**RE: NEW MEXICO WINE PATROL (C18-D29). ENGINEER'S CERTIFICATION FOR  
CERTIFICATE OF OCCUPANCY. ENGINEER'S CERTIFICATION DATED  
OCTOBER 8, 1997.**

TITLE: NEW MEXICO WINE PATROL

DRNG. FILE #: C18/D29

C-2

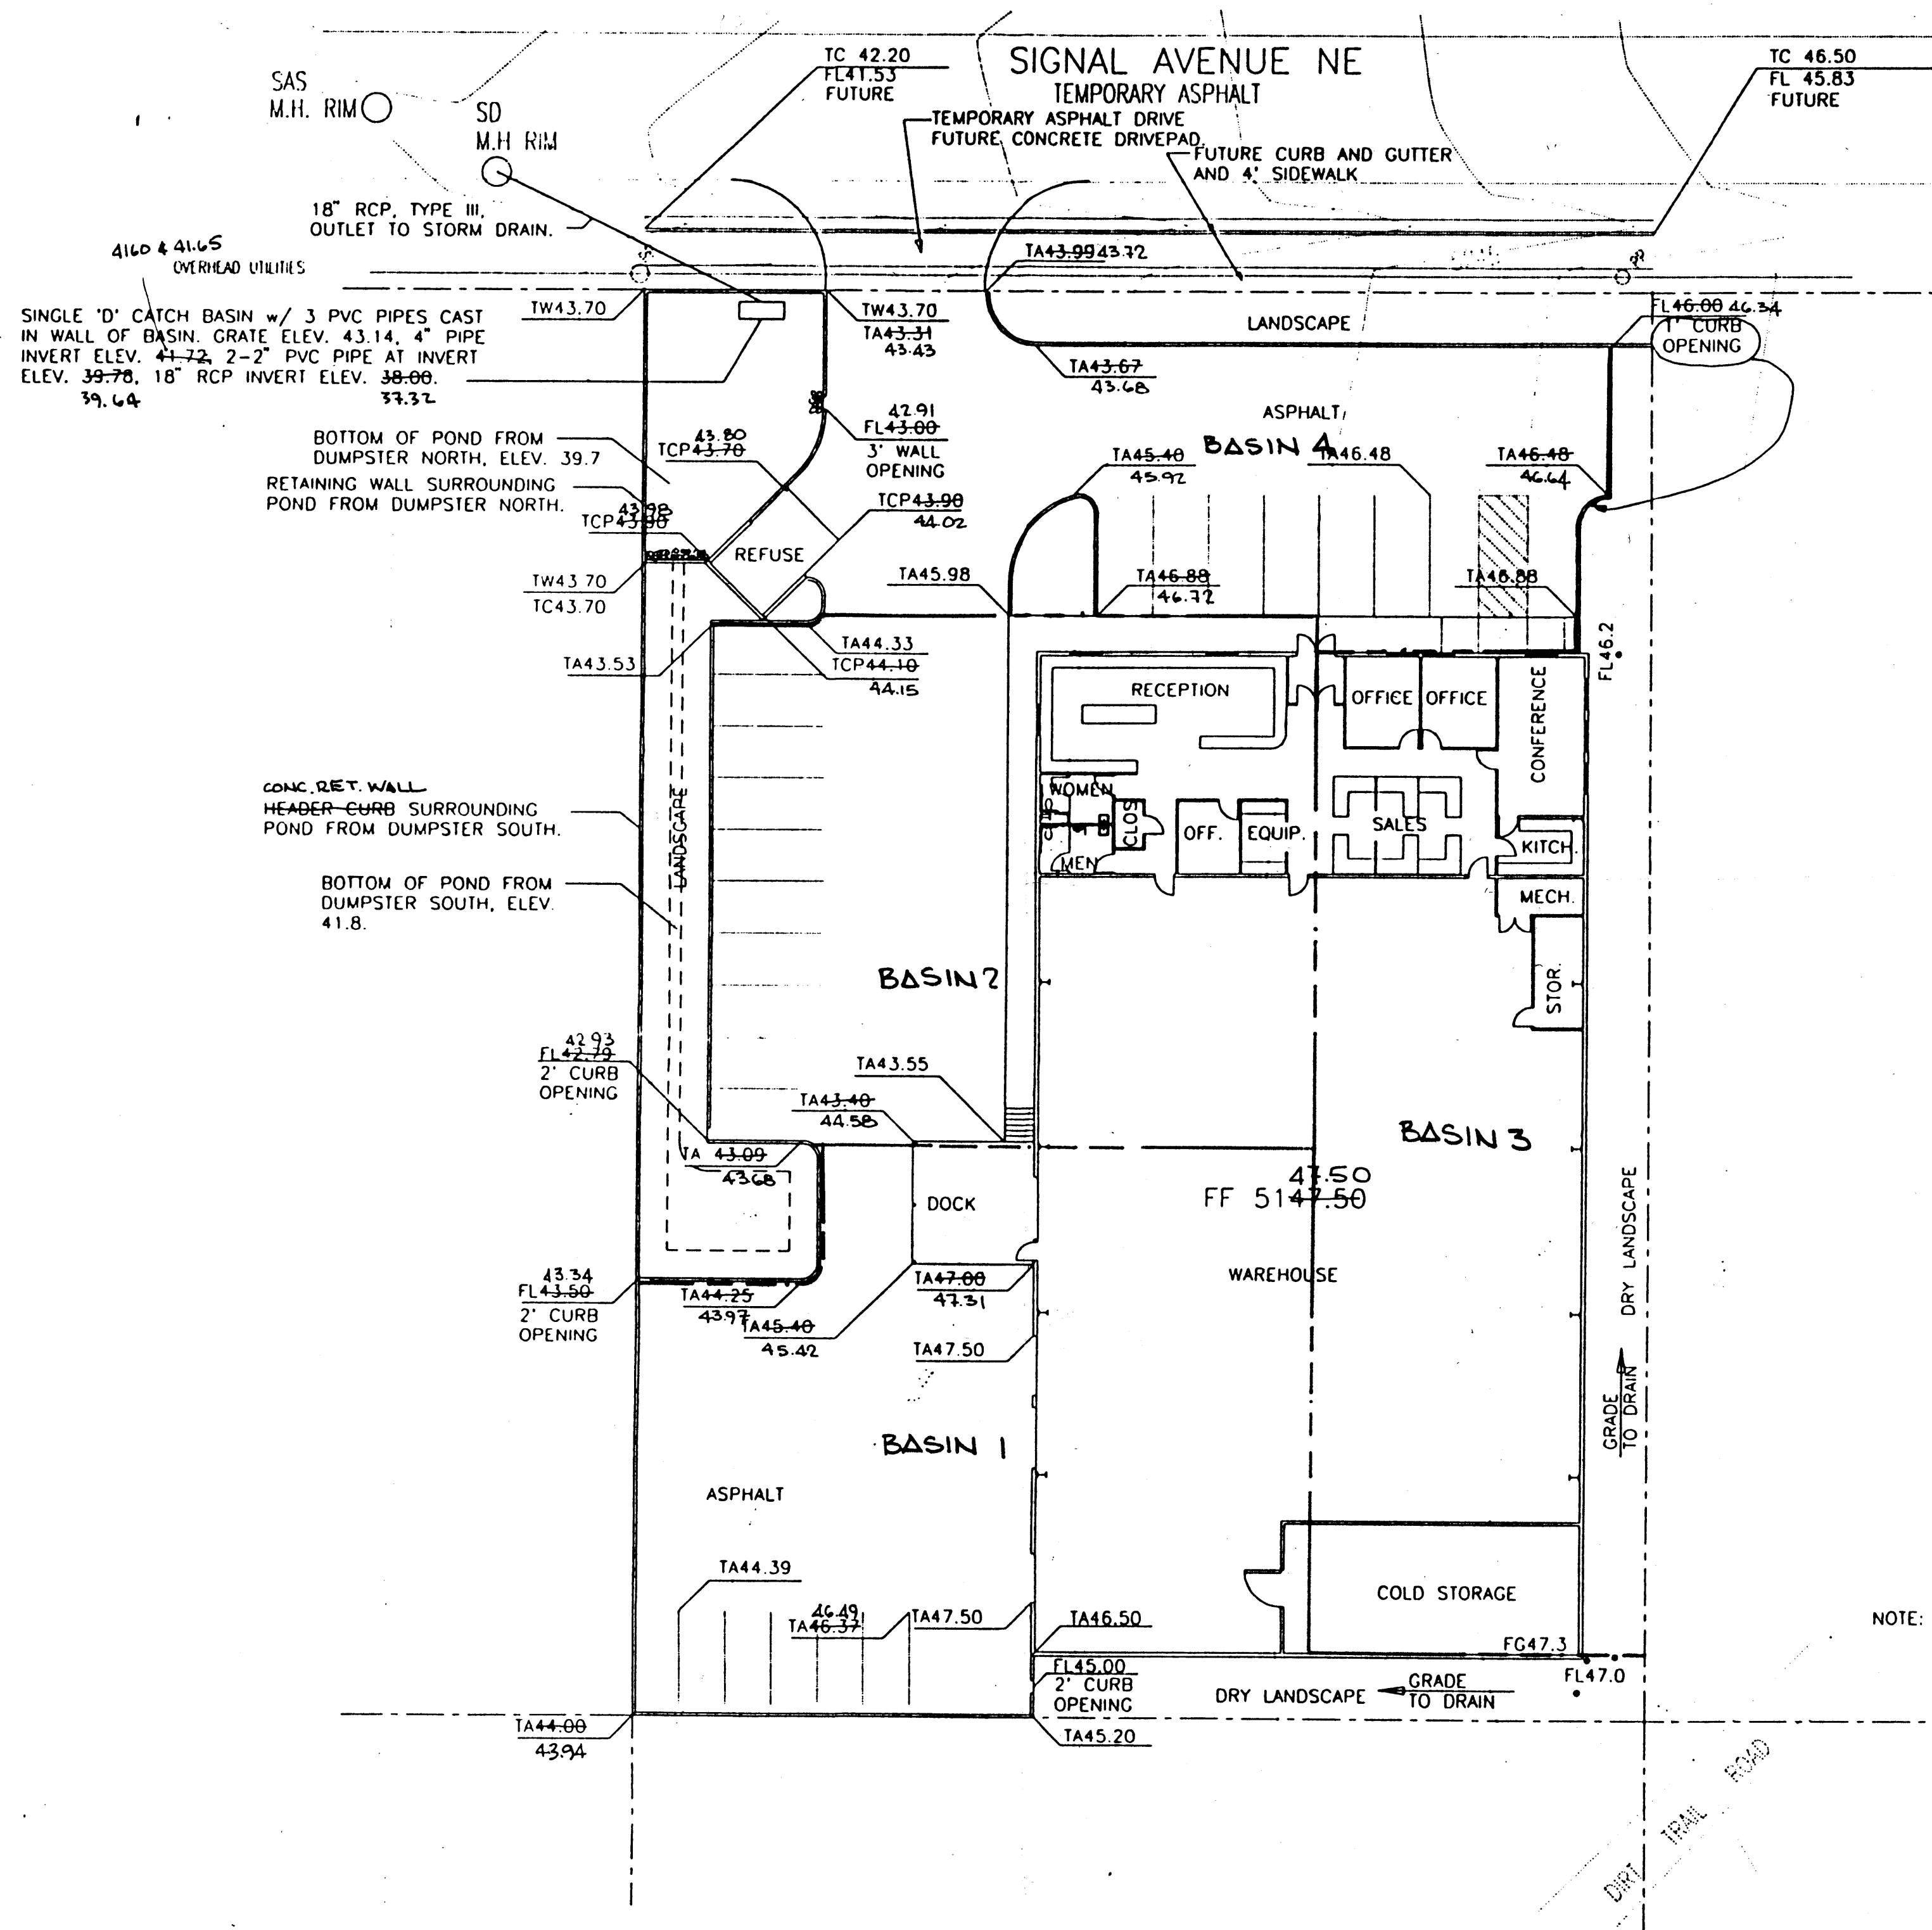
The Header Curb Detail may adversely effect the development of adjacent property if used on property line. Use a wall at property line unless the top of asphalt matches the existing grade. A Work Order will be required to connect the catch basin to the existing storm drain manhole.

Add drainage basin boundaries to drainage plan on sheet C-2A. Indicate the MWSEL & Required Volume of the detention pond on the grading plan on Sheet C-2. What is the invert & width of the wall opening between the north & south ponds? The curb opening at the northeast corner of the parking lot must be 4' wide instead of 1'.
